Your Ref: ACP-324164-26

Our Ref: SID-TN-2026-012

Re: Notification under the Planning and Development Act, 2000, as amended.

Proposed Strategic Infrastructure Development (SID): Renewable energy development Carrow Wind Farm which will include 14 no. wind turbines and associated infrastructure in the townlands of Carrow and adjacent townlands, Co. Tipperary, including underground cabling to connect to the proposed 110kV onsite substation, electrical cabling for 110kV grid connection to the existing Kilonan 110kV Substation, in the townlands of Kilonan and adjacent townlands, Co. Limerick, and all associated infrastructure and works in the townlands of Carrow and adjacent townlands with connection to Substation, in the townlands of Kilonan and adjacent townlands, County Limerick.

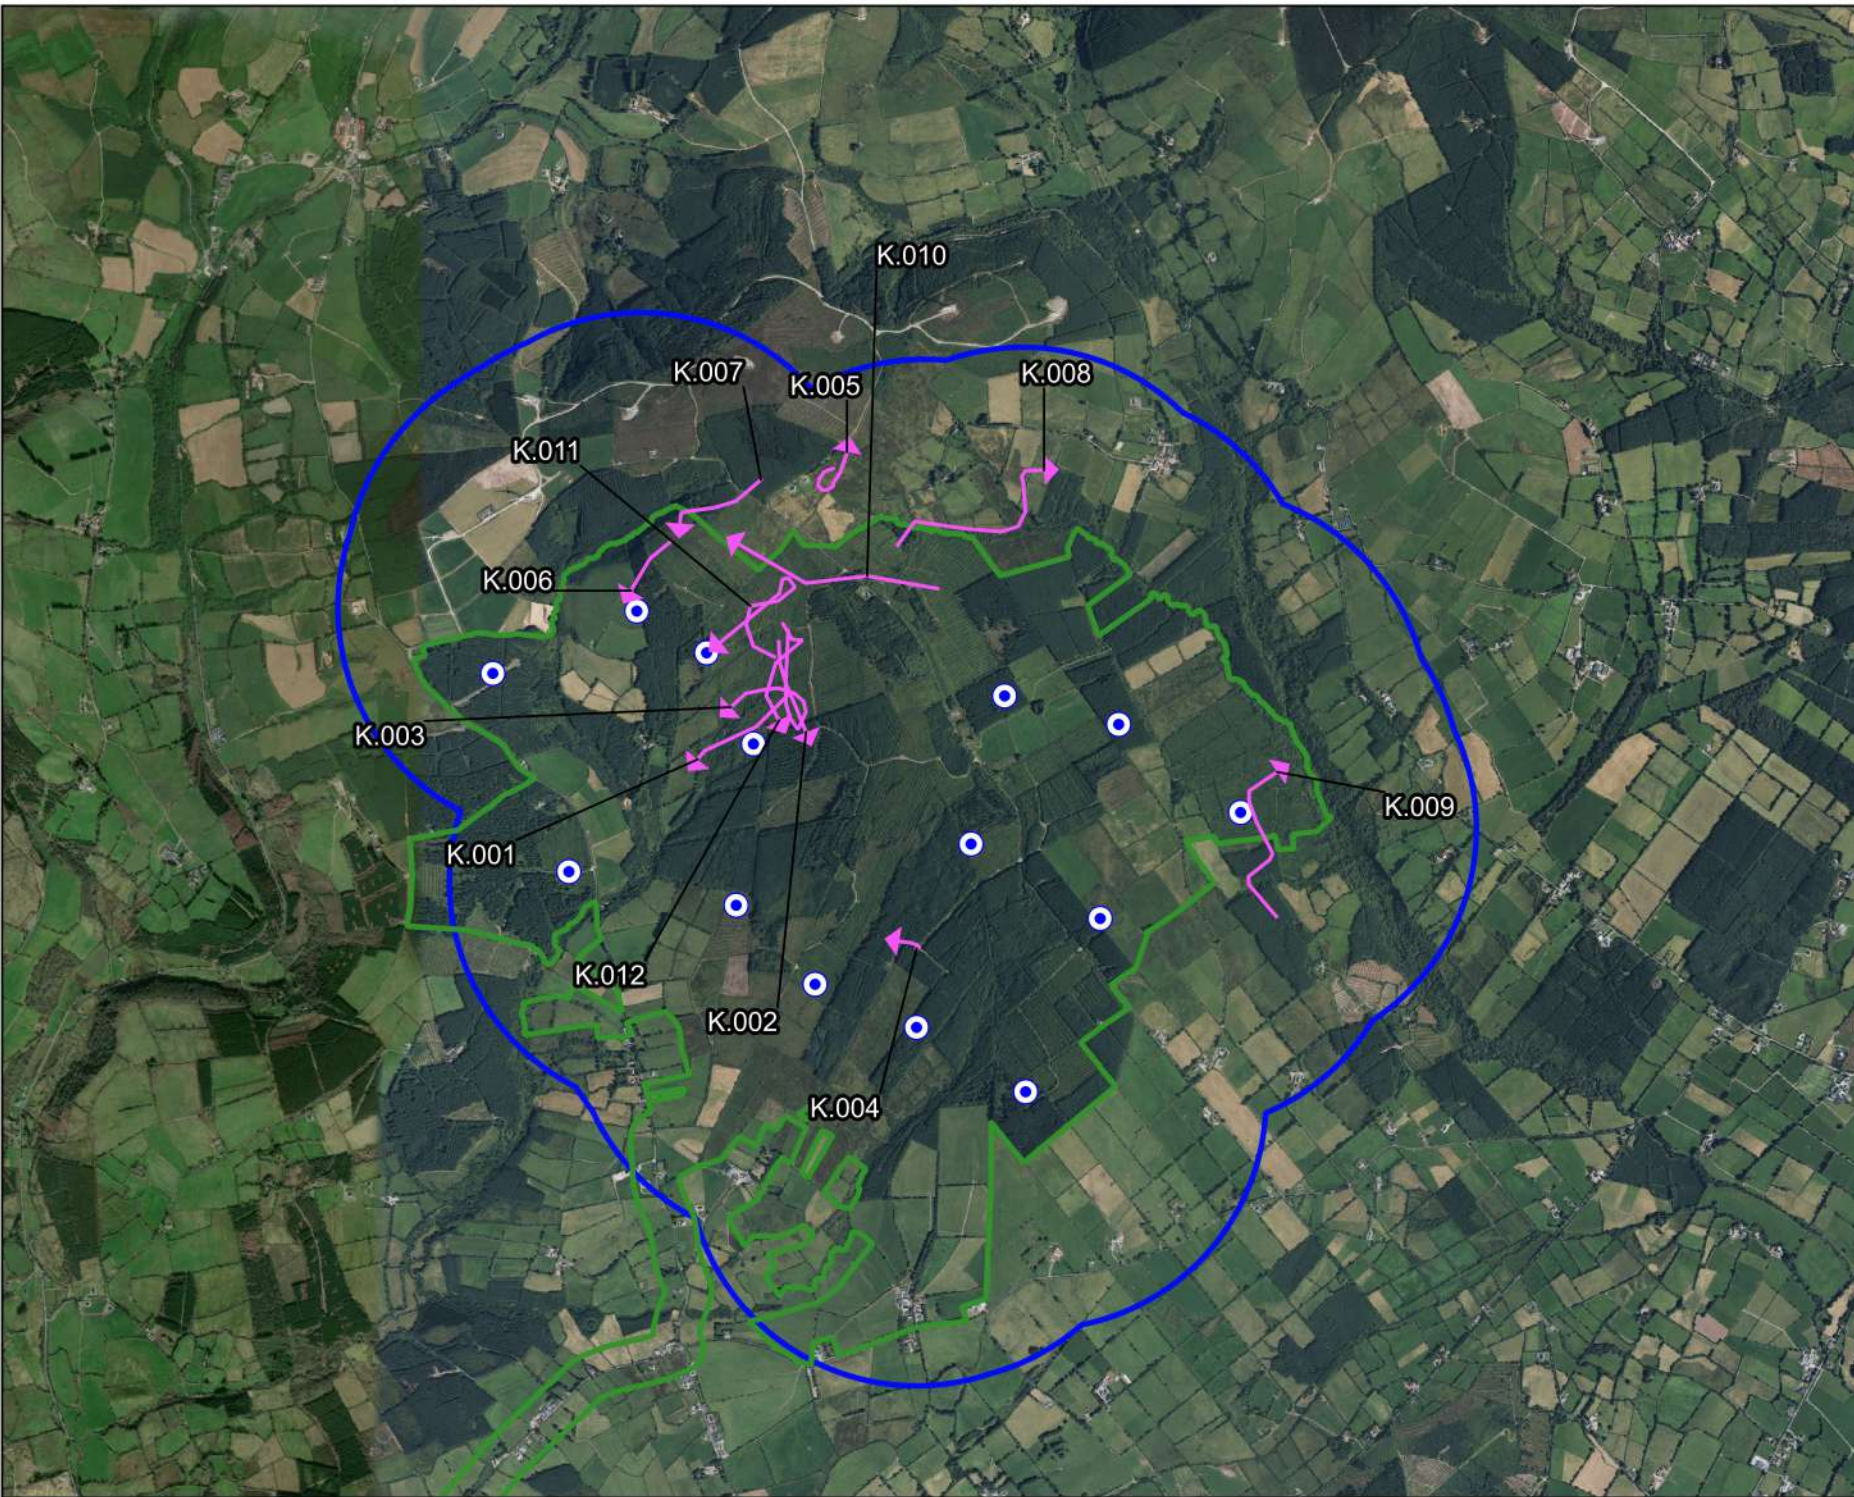
Four breeding Kestrel pairs have been observed on and adjacent to the proposed site, and Kestrels have been observed flying at rotor height. The collision risk has been estimated at 5.4 collisions per year. However, this has been assessed at county level as not significant. The Department considers that this collision risk at site level is highly significant and given that it is related to a breeding population, has implications for breeding success and recruitment, and could potentially lead to the loss of Kestrel as a breeding species from the locality.

The proposal to erect four Kestrel boxes along the site margins as an enhancement measure is also of concern, given the observed usage of the site by Kestrels breeding in adjacent areas, and the projected collision risk.
